Recommendation Report for Planning Permission for Works or Extension to a Dwelling

REF NO: R/61/22/HH

LOCATION: Rustlings
14 Wendy Ridge
Rustington
BN16 3PJ

PROPOSAL: Single storey rear extension.

P2	ISSUED FOR PLANNING	24.03.2022
P1	ISSUED FOR PLANNING	27.07.2021
REV	DESCRIPTION	DATE
DRAWING		
BLOCK PLAN		
14 WENDY RIDGE, RUSTINGTON, LITTLEHAMPTON, WEST SUSSEX, BN16 3PJ		
SCALE @ A3	DATE	DRG No
1:500 , 1:1250	MARCH 2022	DE 1009 / 06
		REVISION
		P2

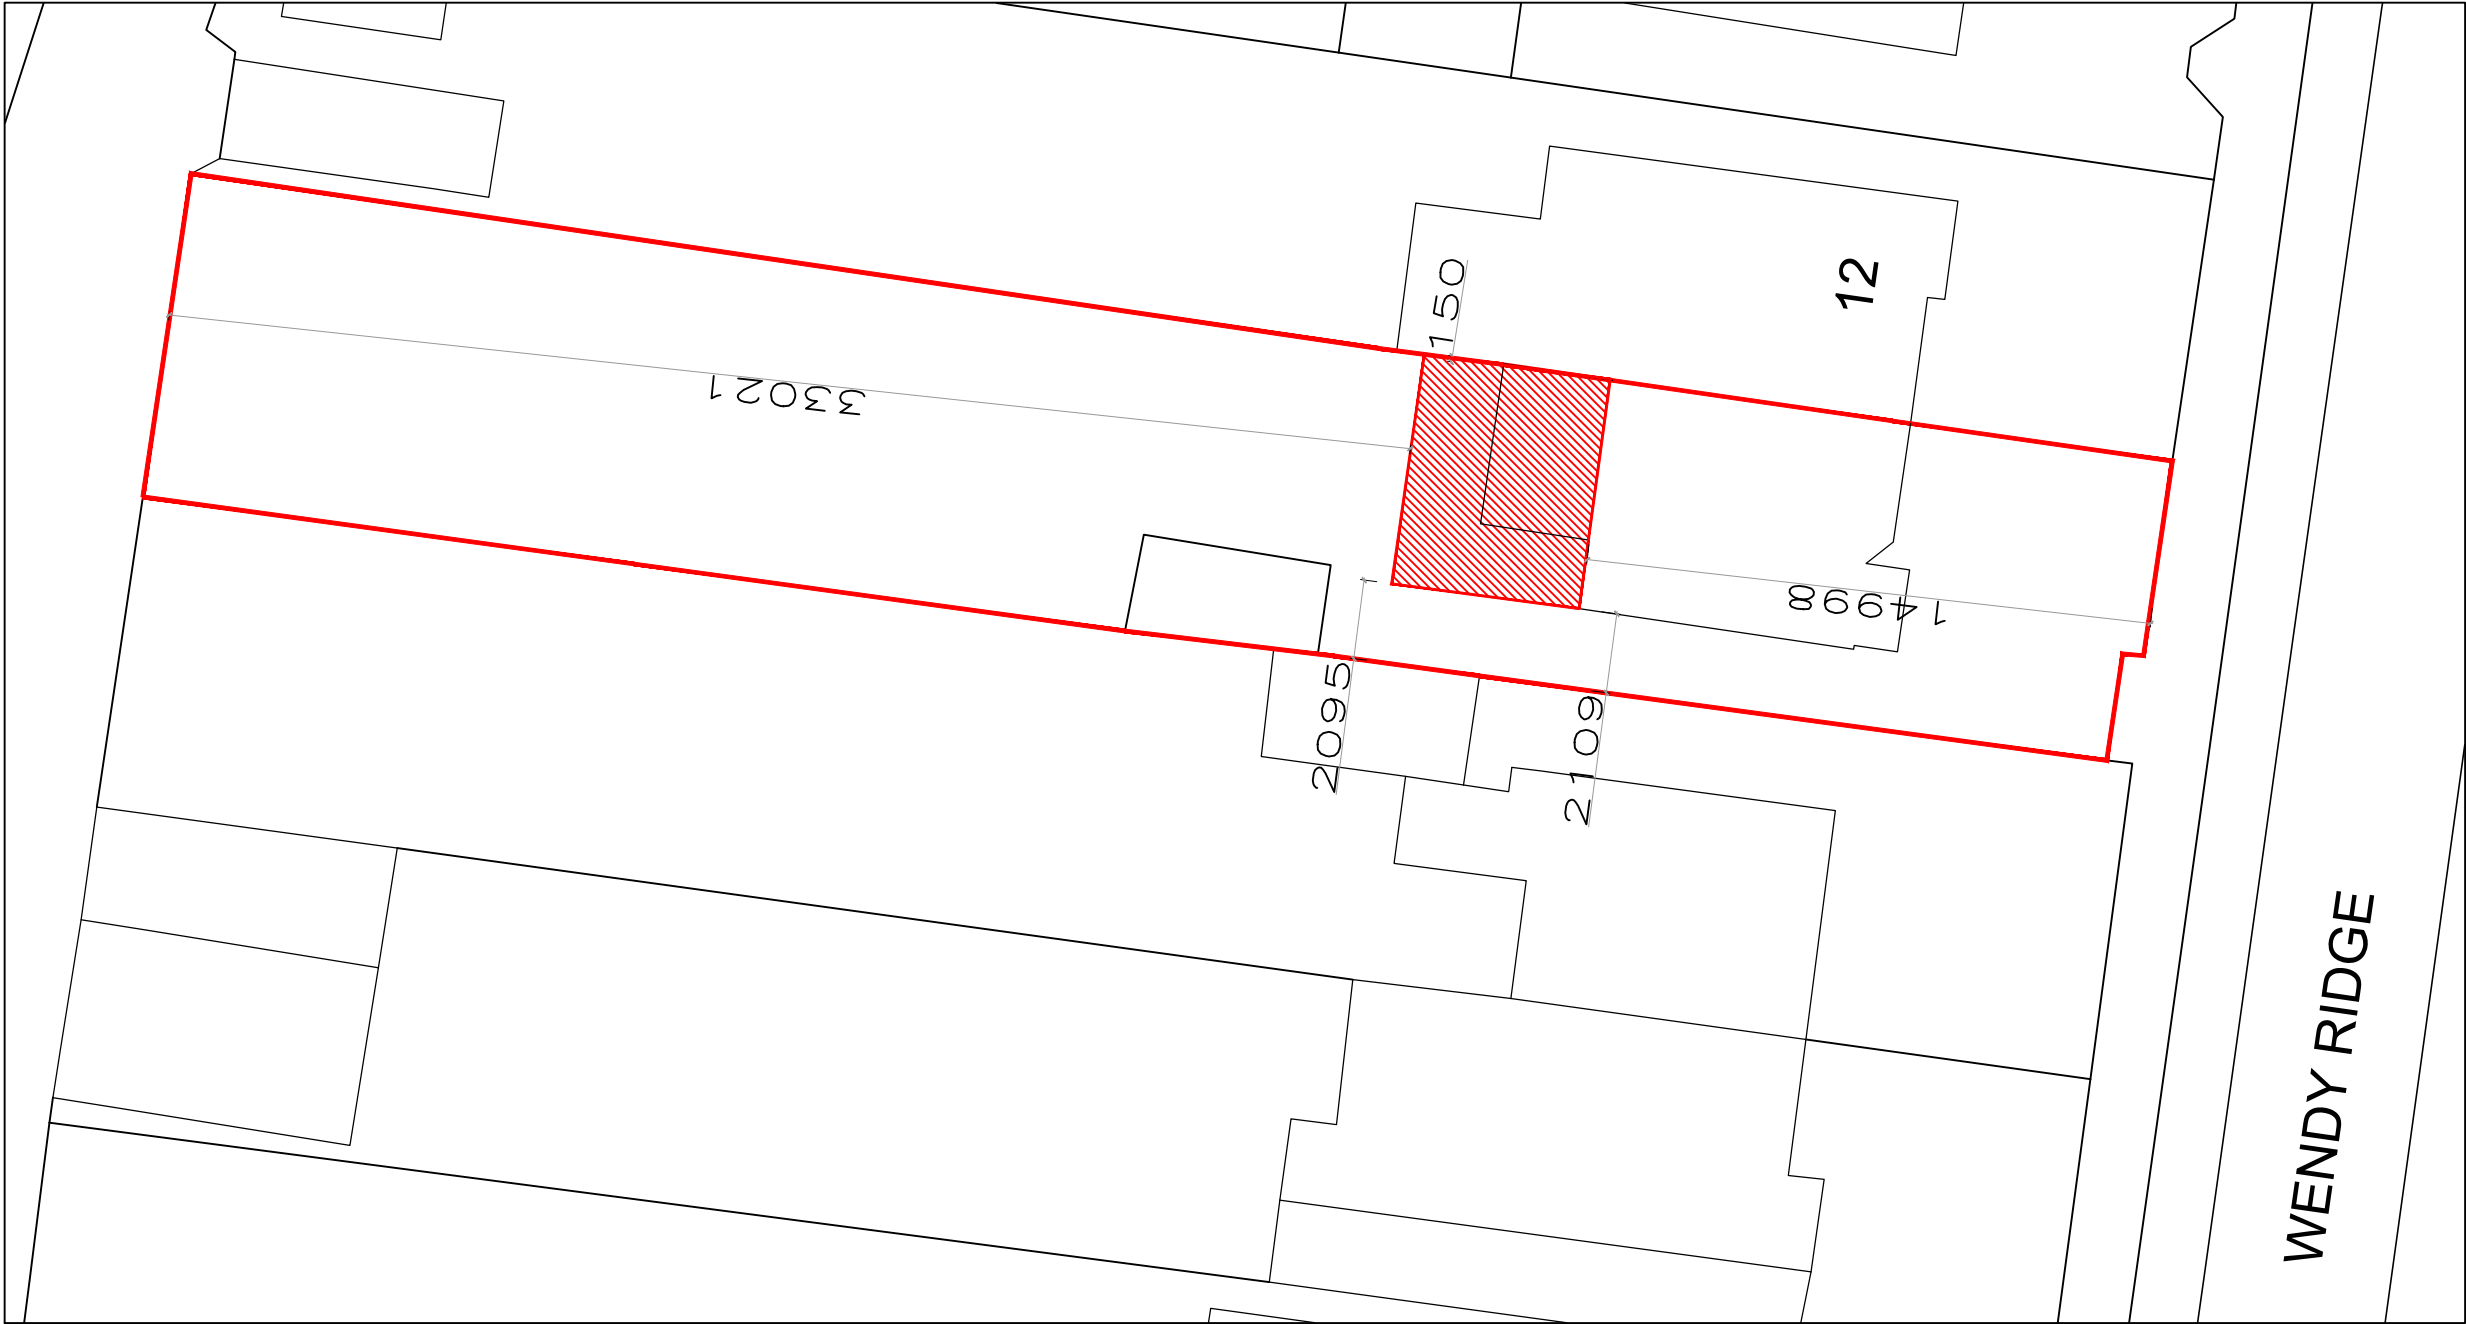
The siting and scale of the development is such that the proposal does not intersect 60-degree sightlines or 45-degree light accessibility lines from the rear of any neighbouring dwellings. As such, the proposal does not give rise to any adverse impacts by way of overbearing or overshadowing on neighbour dwellings.

P2	ISSUED FOR PLANNING	24.03.2022
P1	ISSUED FOR PLANNING	27.07.2021
REV	DESCRIPTION	DATE
DRAWING PROPOSED FLOOR PLANS AND ELEVATIONS 14 WENDY RIDGE, RUSTINGTON, LITTLEHAMPTON, WEST SUSSEX, BN16 3PJ		
SCALE @ A3 1:100	DATE MARCH 2022	DRG No DE 1009 / 03
		REVISION P2

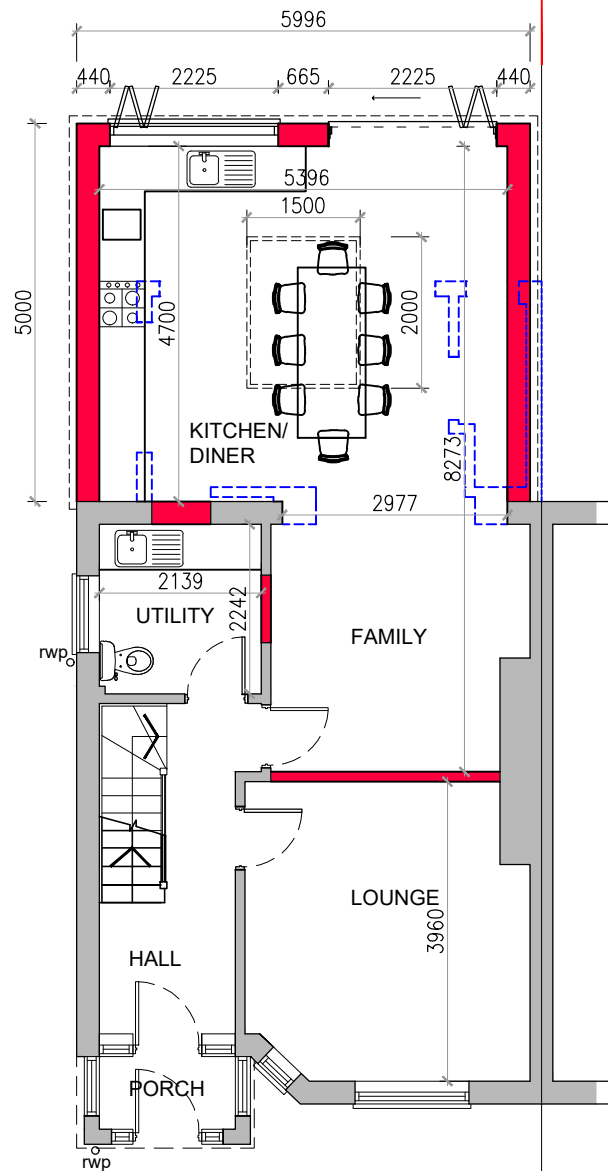
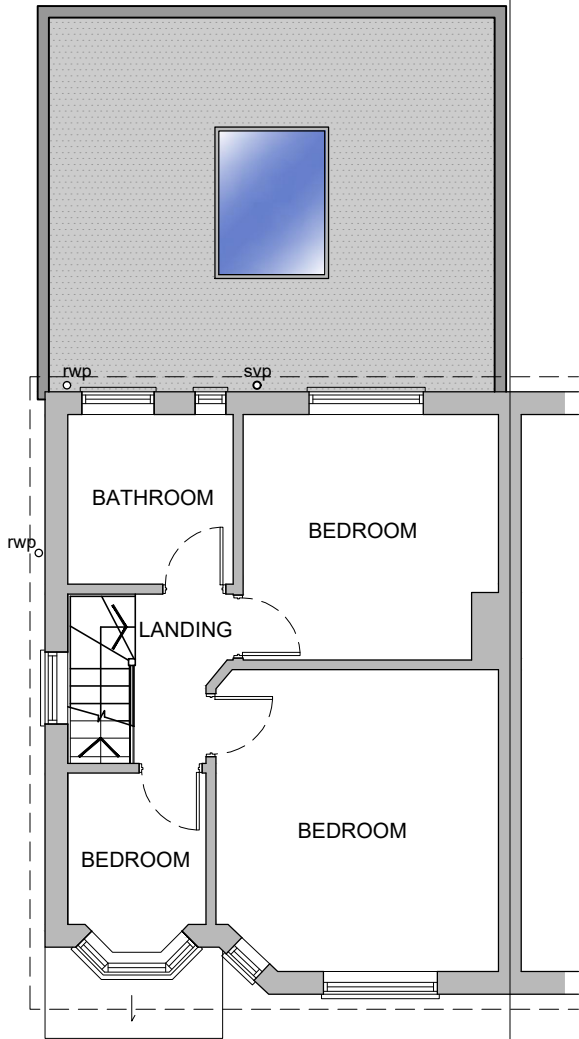
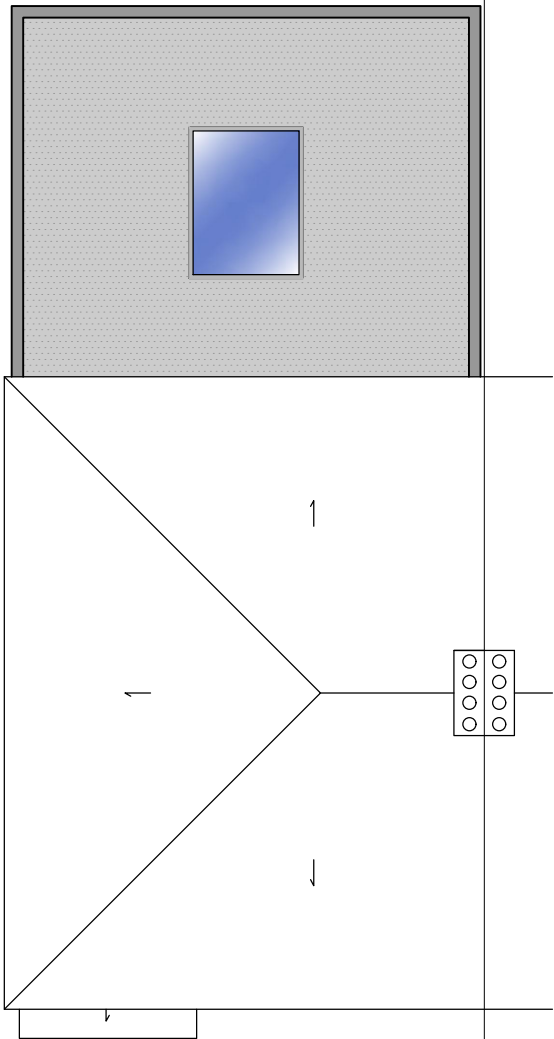
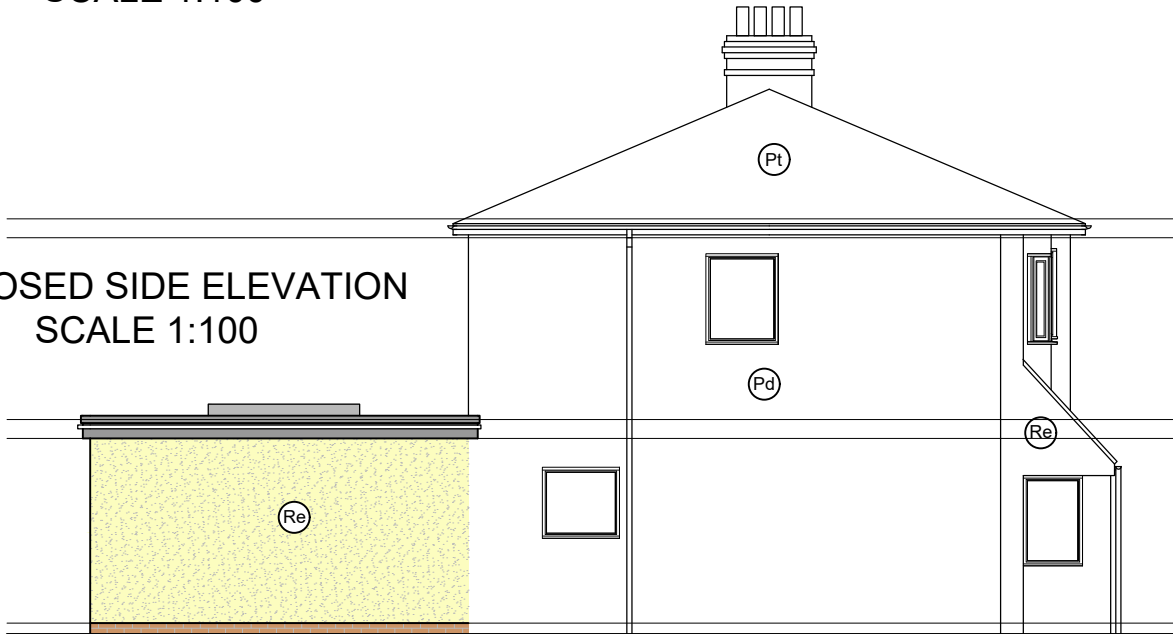
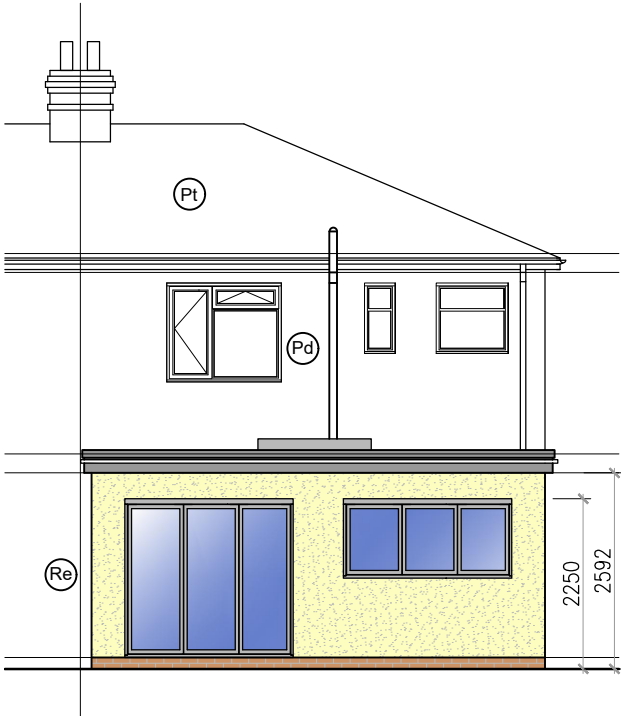
The single storey rear extension is approx. 5m in depth, 6m in width and 3m in height with a flat roof design that also features 1 No. rooflight. The scale of the extension is large relative to the host dwelling, however, it remains visually subservient to the dwelling and it is not out of character within its locality as many large rear extensions can be found within the locality. It is to consist of matching materials to those found on the dwelling and consists of a visually integrated design. It is to the rear with minimal/no views from the wider street scene. As such, the proposal is will have no adverse visual impact on the street scene.

The rear extension is to feature a set of rear glass doors and 3 No. rear glass windows. These are to look out to the rear garden and do not give rise to any adverse impacts of overlooking.
